Application for Removal or Variation of a Condition following Grant of Planning Permission or Listed Building Consent

Installation of a new shop front, provision of balcony with 1.1m high privacy screen to rear 2nd floor, installation of roof lantern to rear and use as altered as retail and office space at ground floor and 2 serviced holiday flats to 1st and 2nd floors

23/0411

Condition 2: Change approved drawings: A023/061/BR/02 Revision A to A023/061/BR/02 Rev B and A023/061/BR/01 Revision D to A023/061/BR/01 Revision E

Revision  
E  
DRAWING No. AO23/06/1/BR/O1

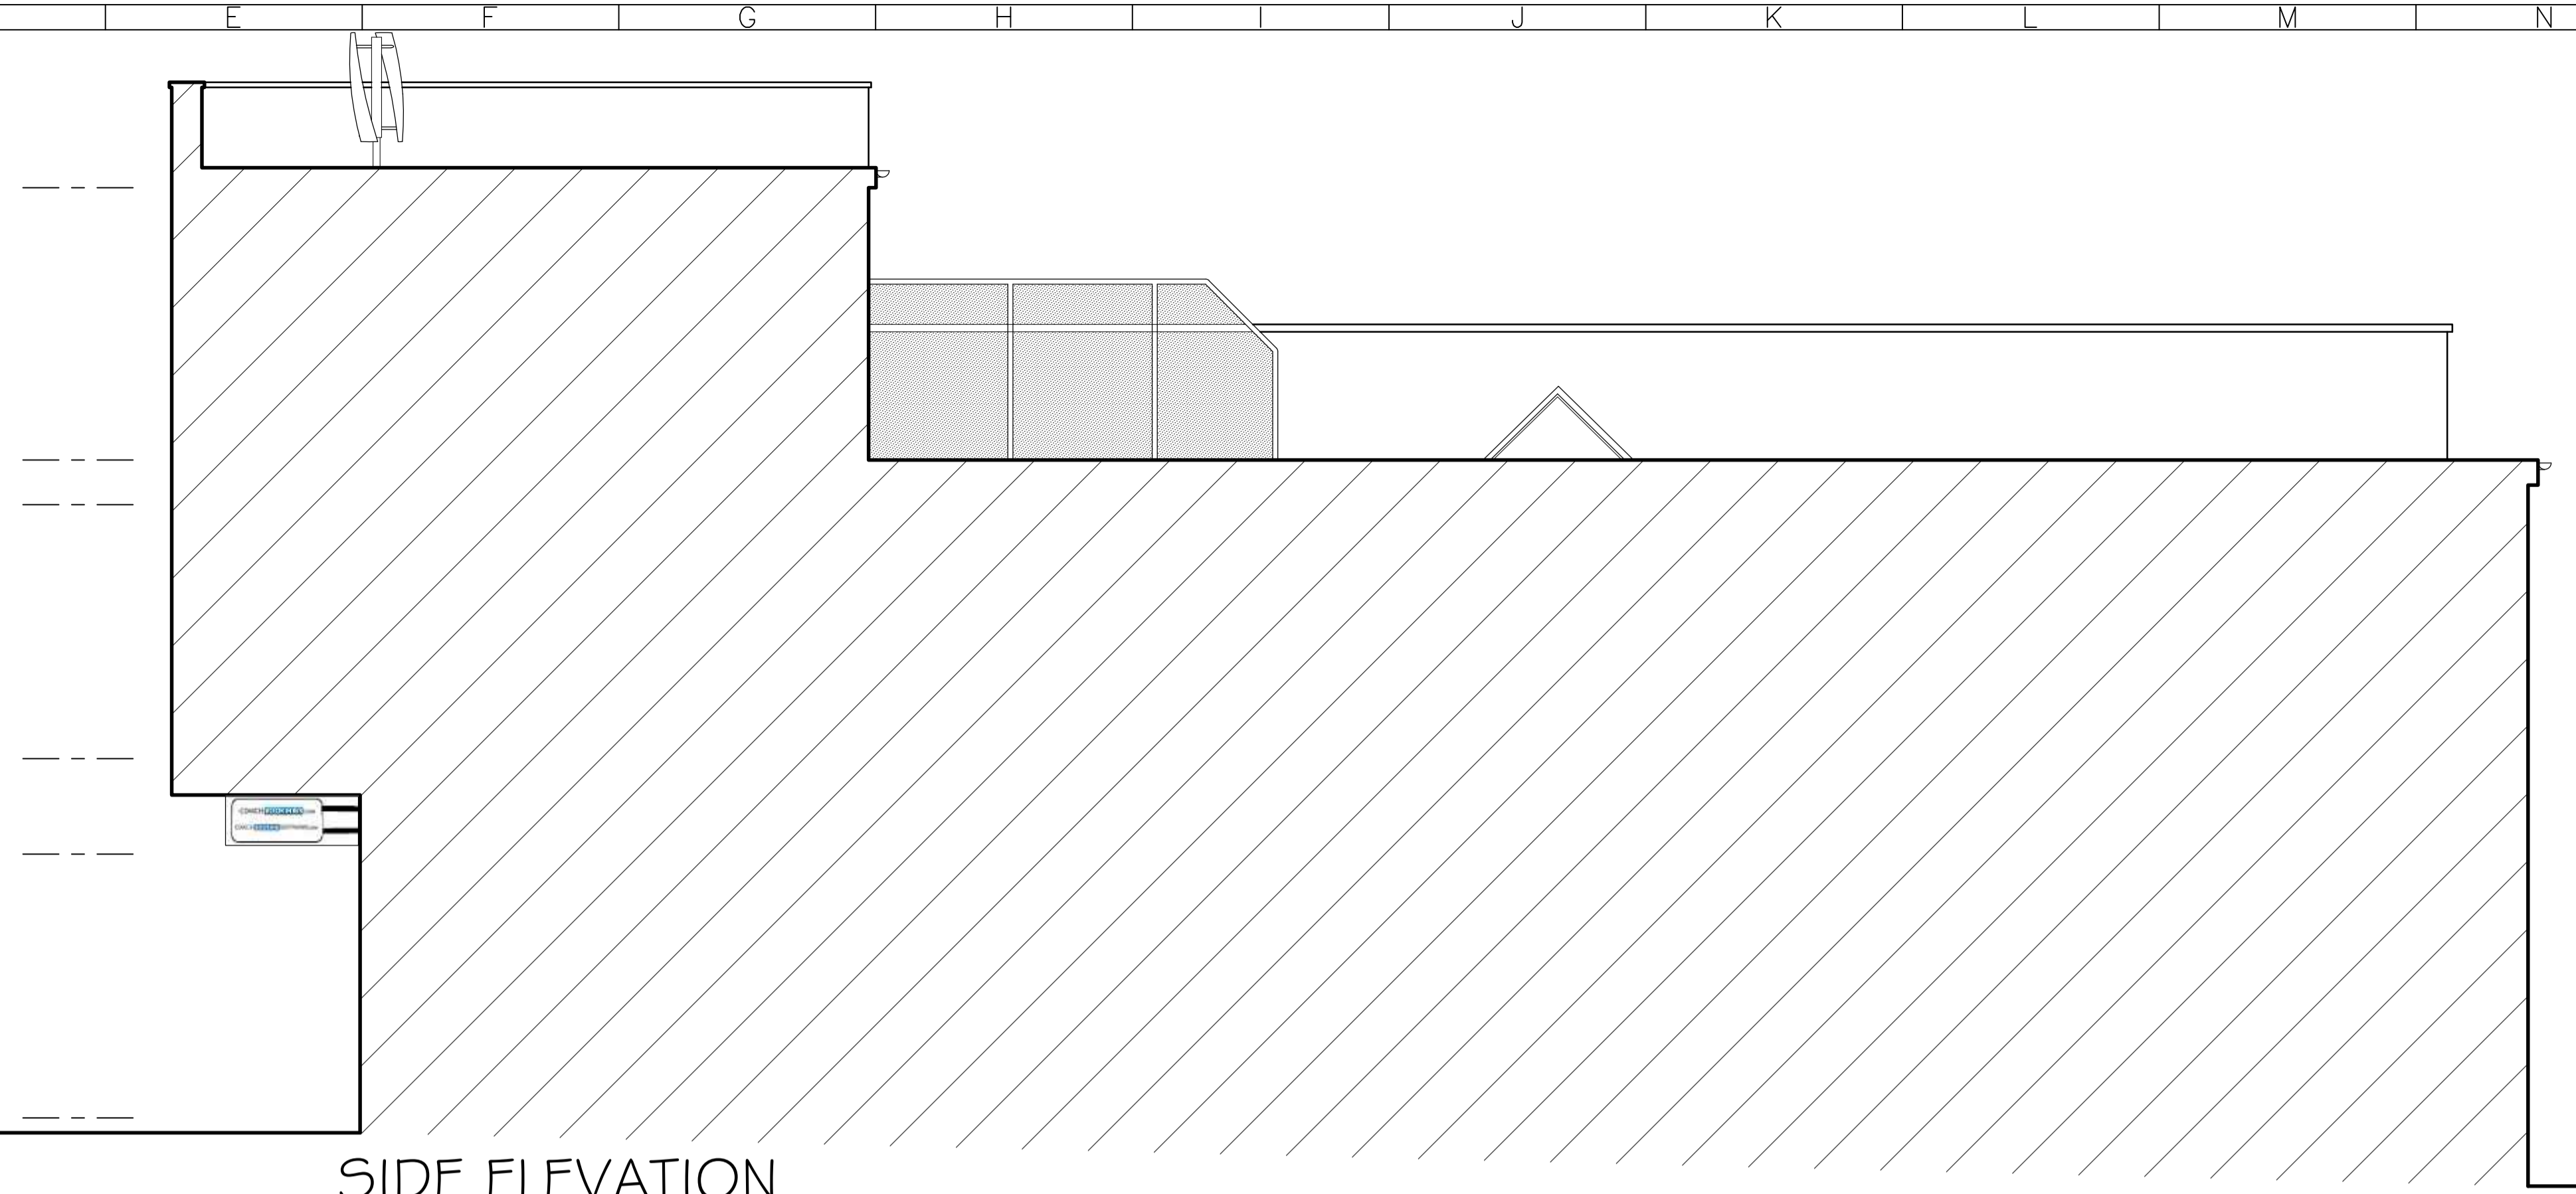
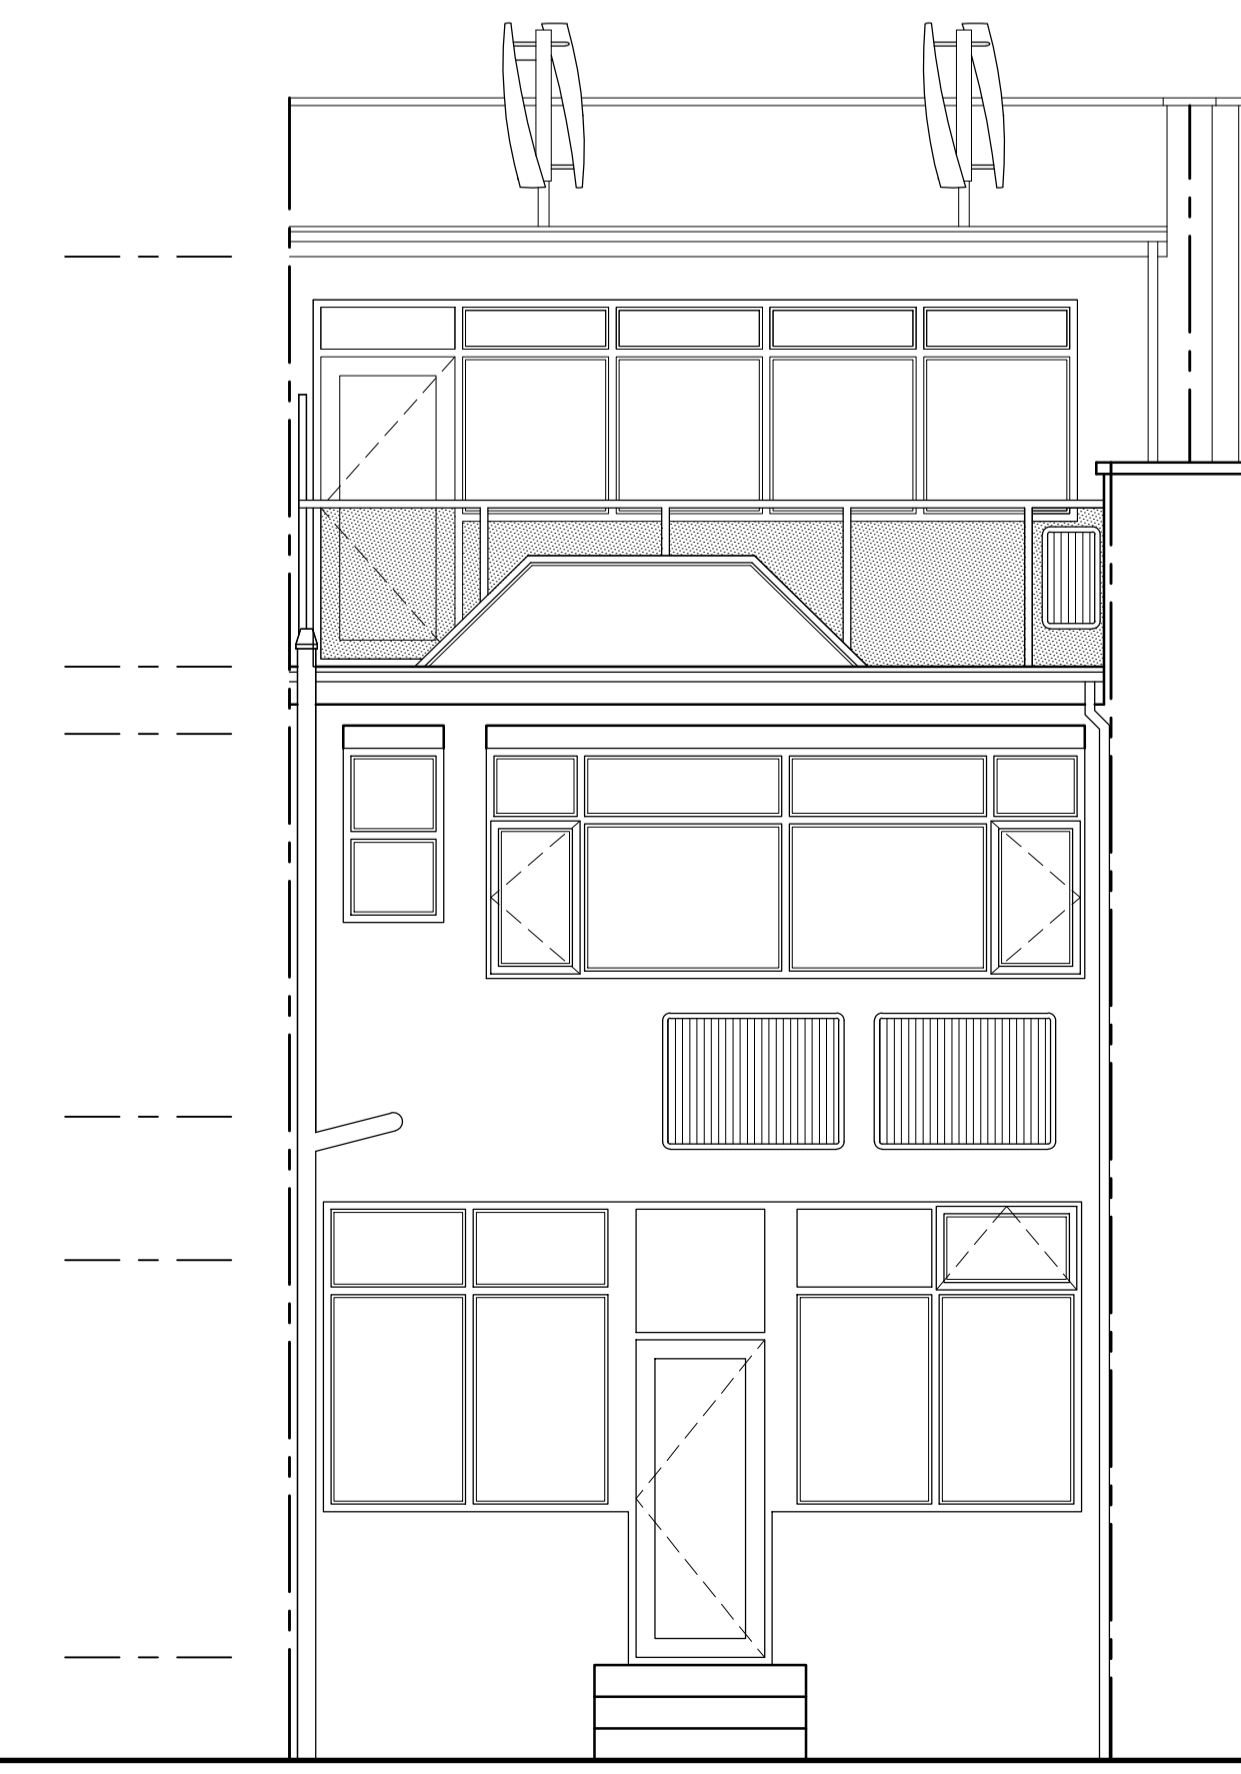
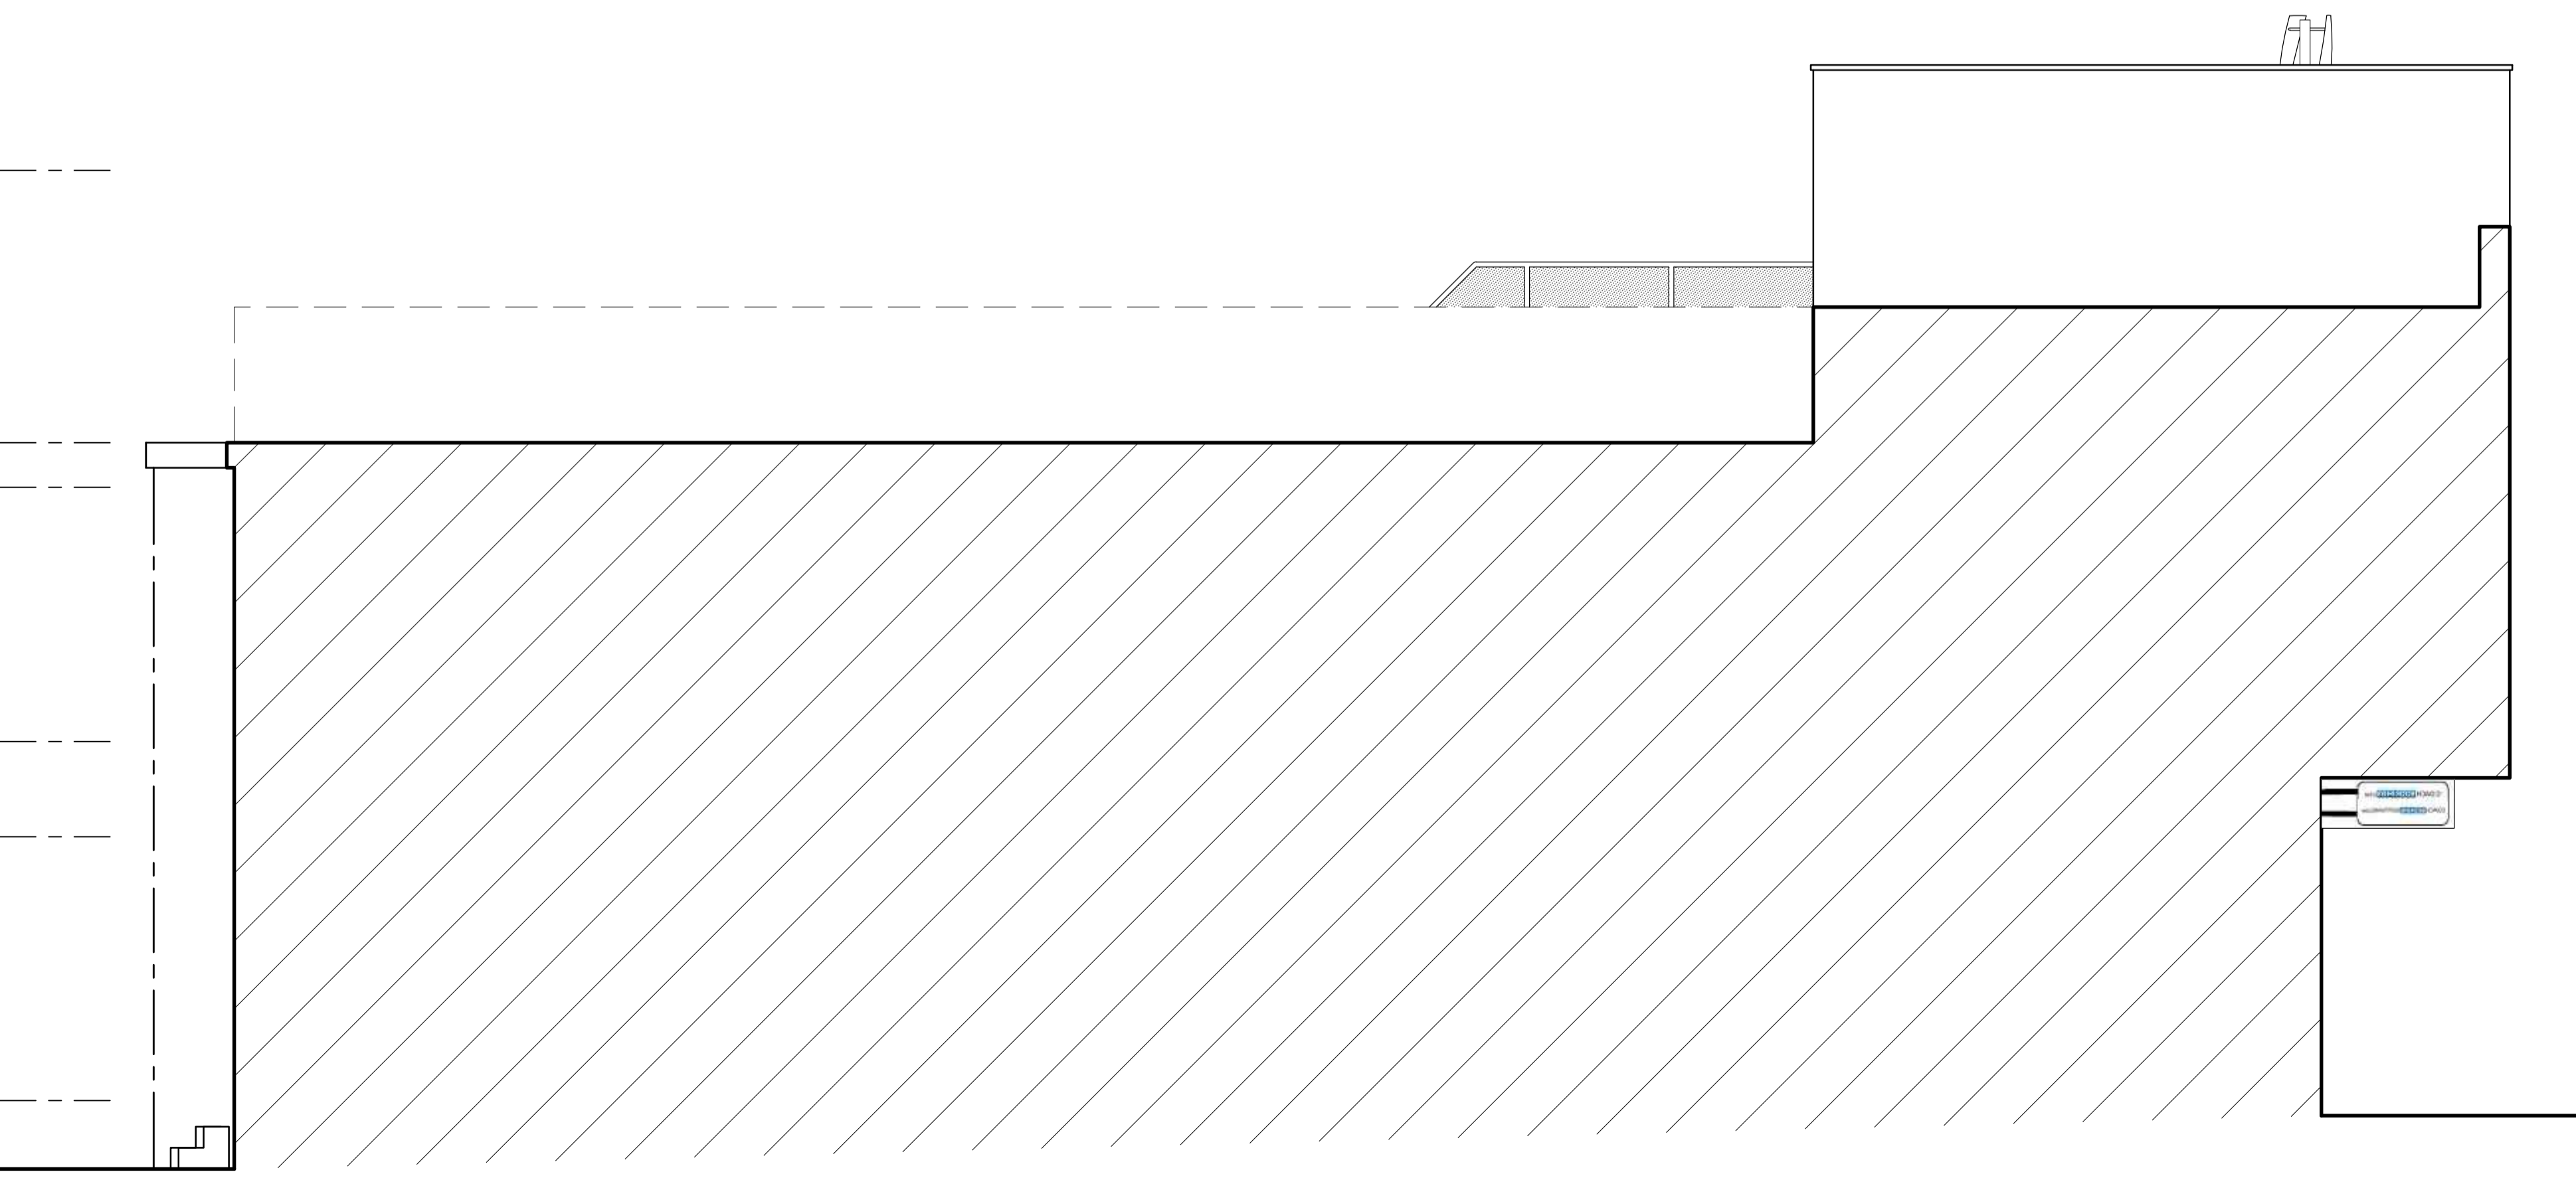
Sub divide the windows to make more user friendly and increase security to the ground floor
